Project Name: New Yard

Address: 528 COMMERCIAL ST

Marge Schmuckal - New Yard Boat Maintenance bldg - #2013-02298

From: Marge Schmuckal
To: flight@portlandyacht.com
Date: 10/10/2013 11:11 AM
Subject: New Yard Boat Maintenance bldg - #2013-02298

Drawing file: Plans / C-2.2 SITE DEVELOPMENT PLAN PHASE 1A SUMMER FALL AND 1B.pdf

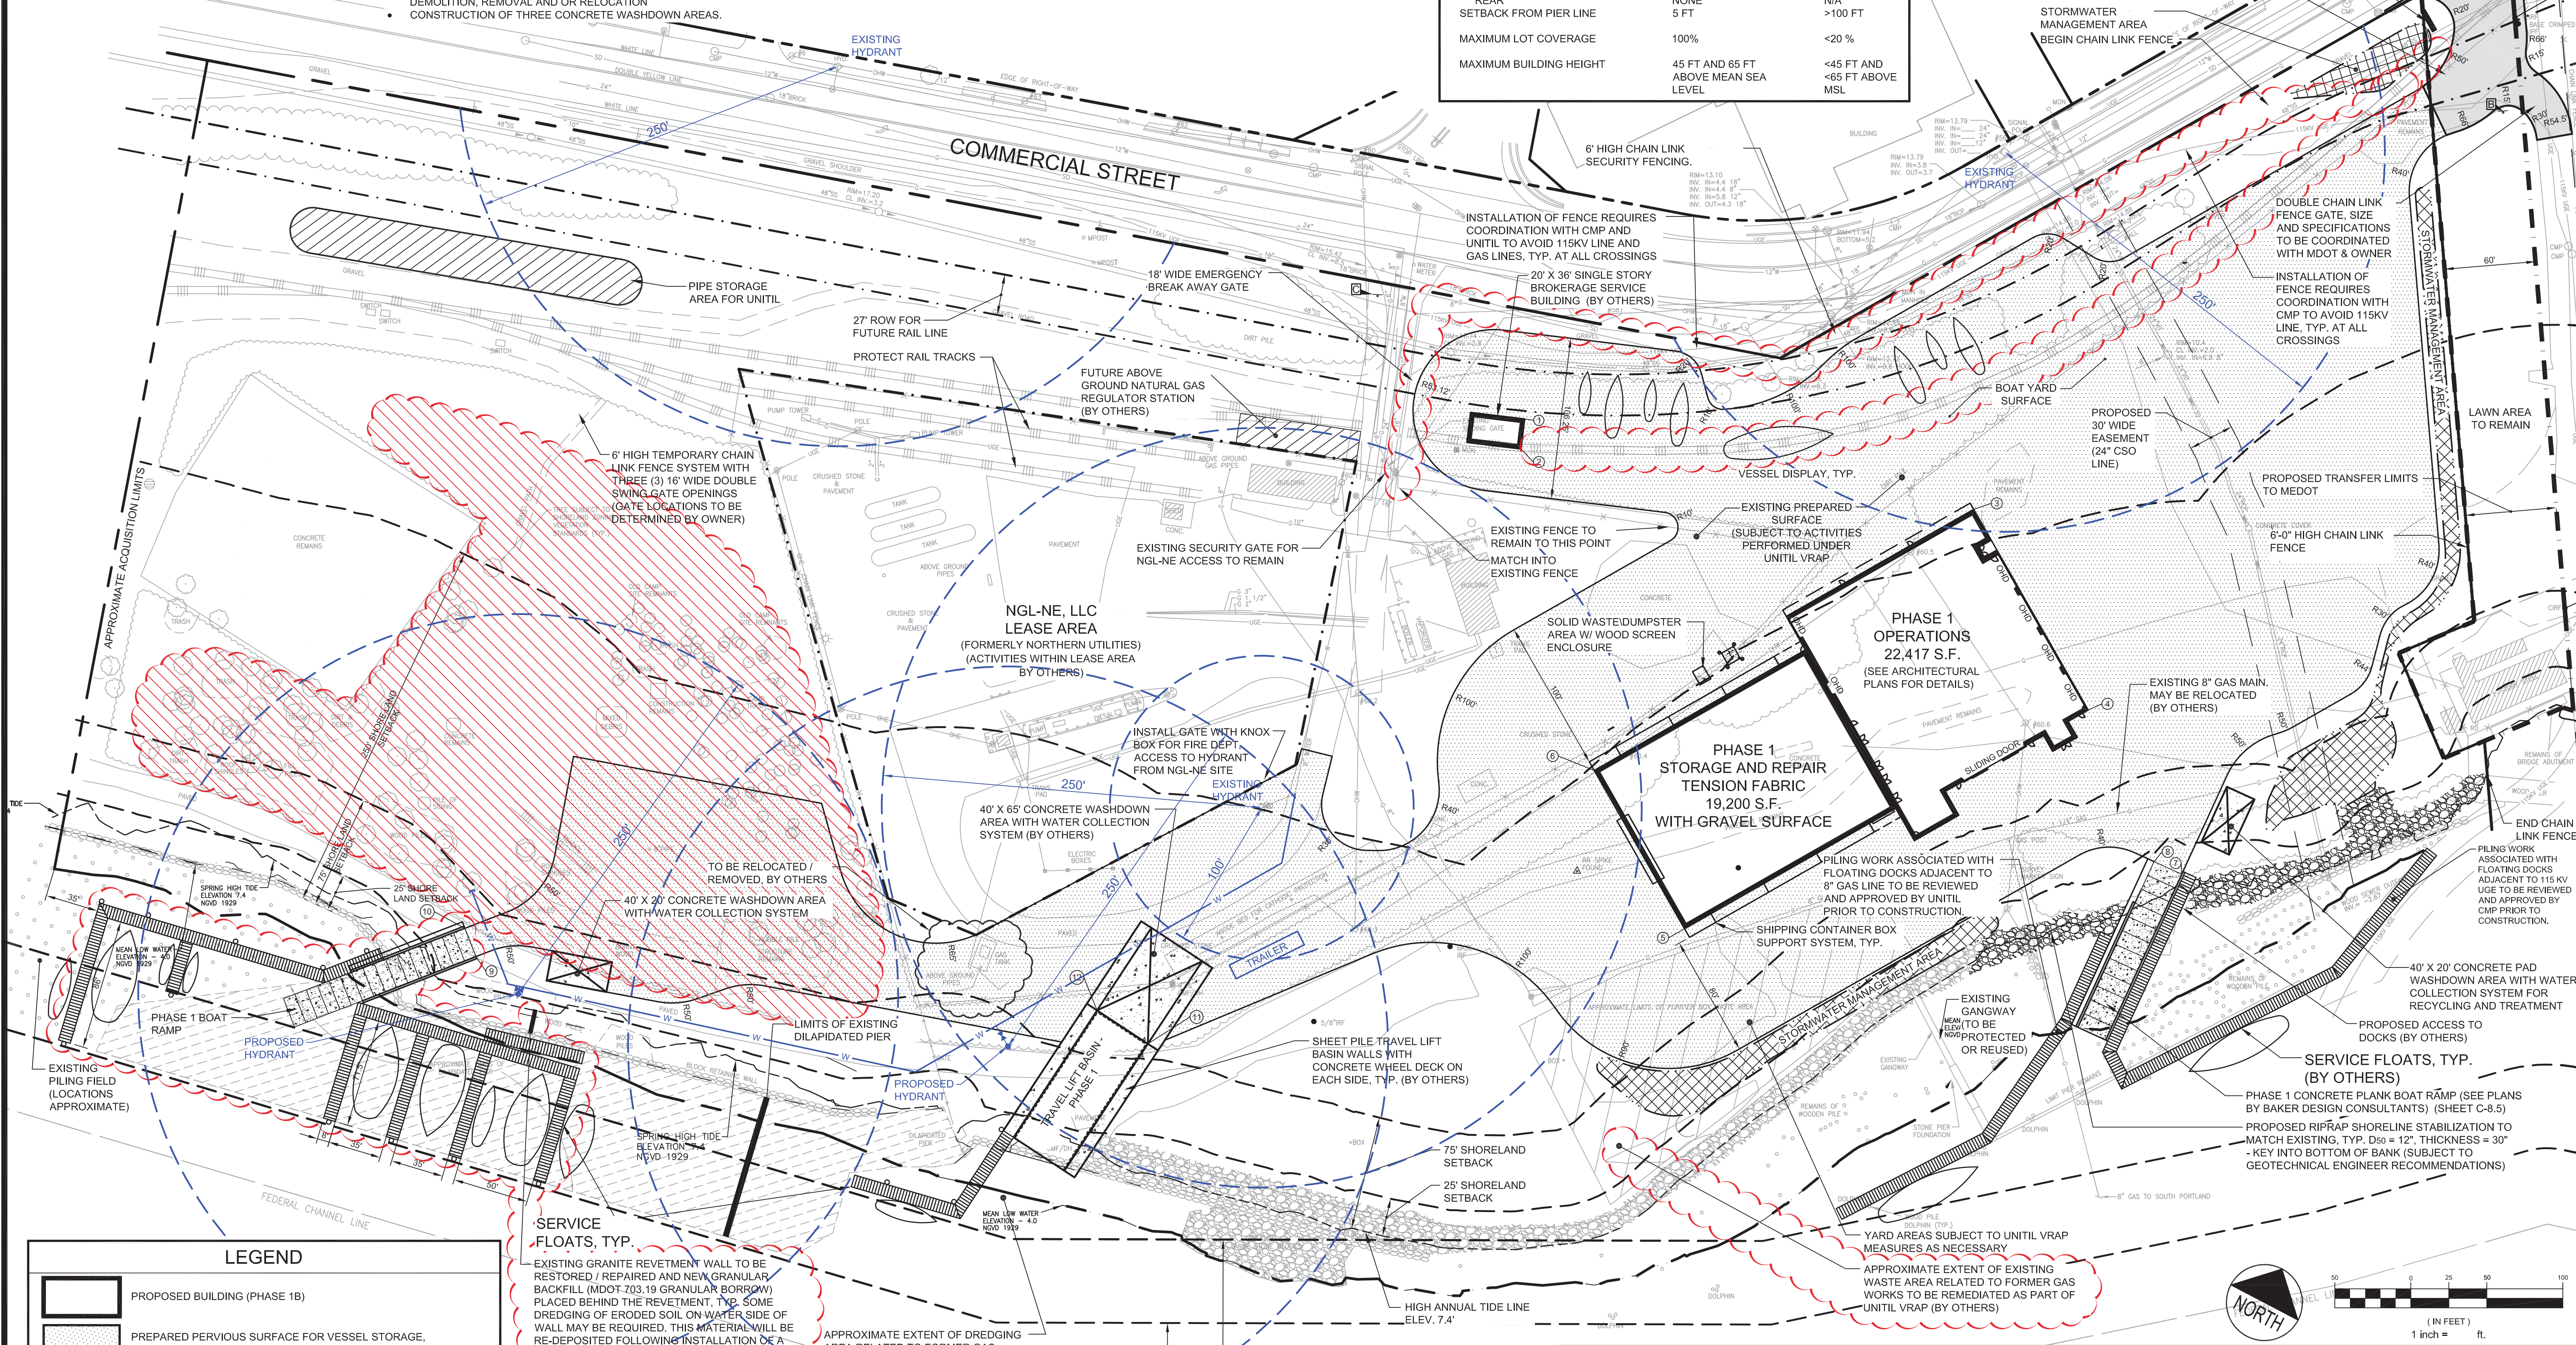
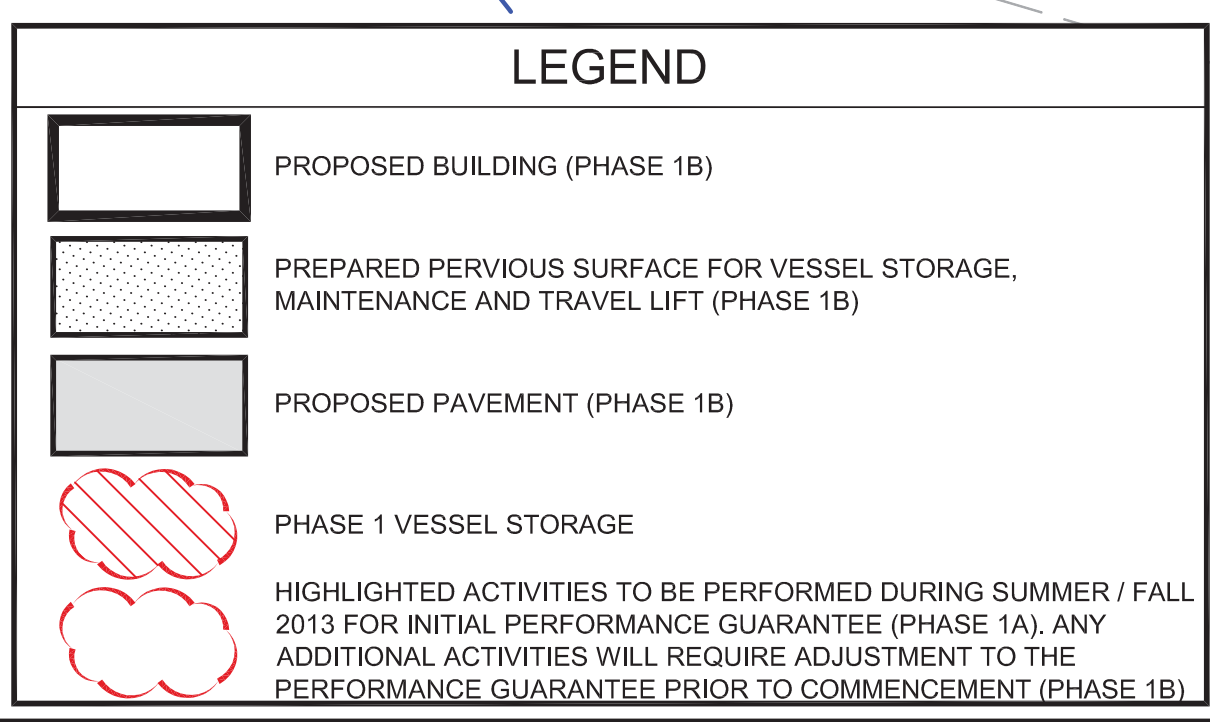
I have your application for the new boat maintenance facility. I need more specific information on the height of the structure and also how the height of the structure meets the other requirement of being no higher than 65' above the mean sea level. I will need all that documentation.

Drawing file: Plans / C-3.1 AMENDED GRADING AND DRAINAGE PLAN PHASE 1B.pdf

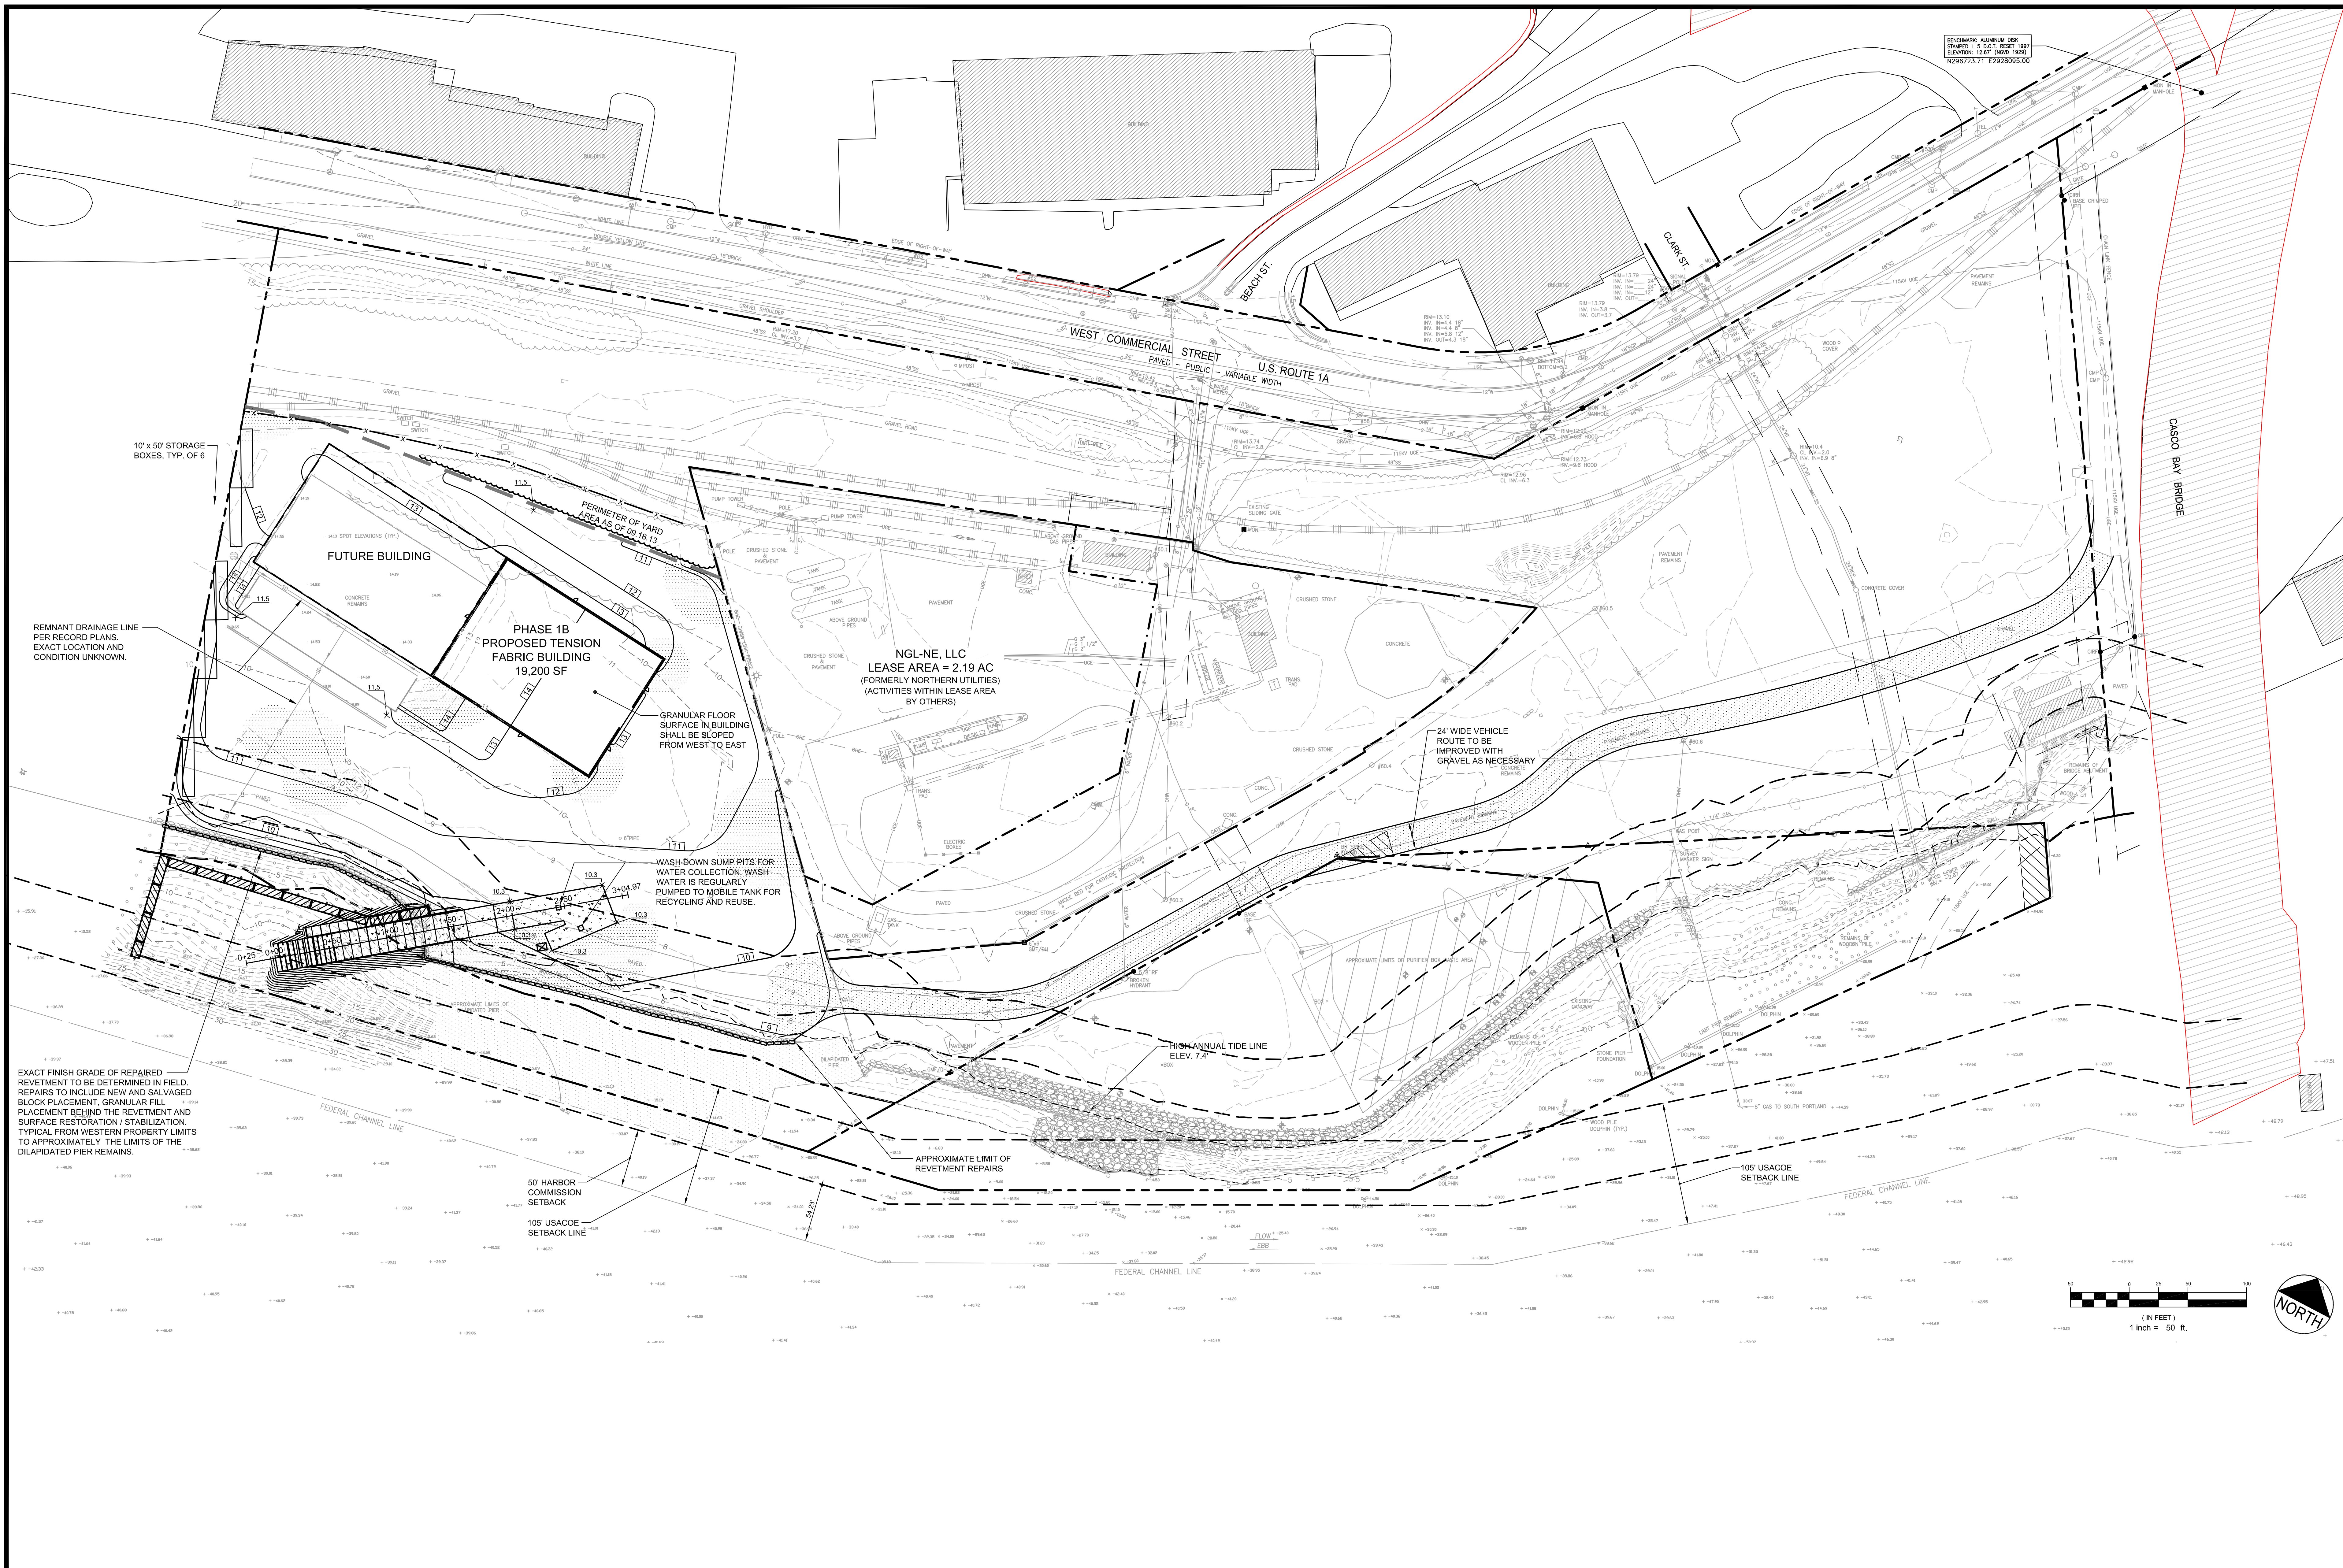
This new structure also needs to comply with the underlying flood zone. I do not see the first floor elevation documented on the plans. The property is located in an A-2 flood zone with an elevation of 10'. The City's Ordinance requires the first floor elevation to be at least at elevation 12' (2 feet above the given elevation). There are flood forms that need to be filled out by you and returned. First a certificate of elevation needs to be filled out to document what the 1st floor elevation is supposed to be. Part I of the elevation would allow you to begin construction (after the permit issued). After the slab is poured, a certificate of elevation confirming the actual constructed first floor elevation is completed and submitted. Once the first floor elevation is confirmed by me as meeting the Floodplain rules, a part II application gives you permission to continue building the rest of the structure.
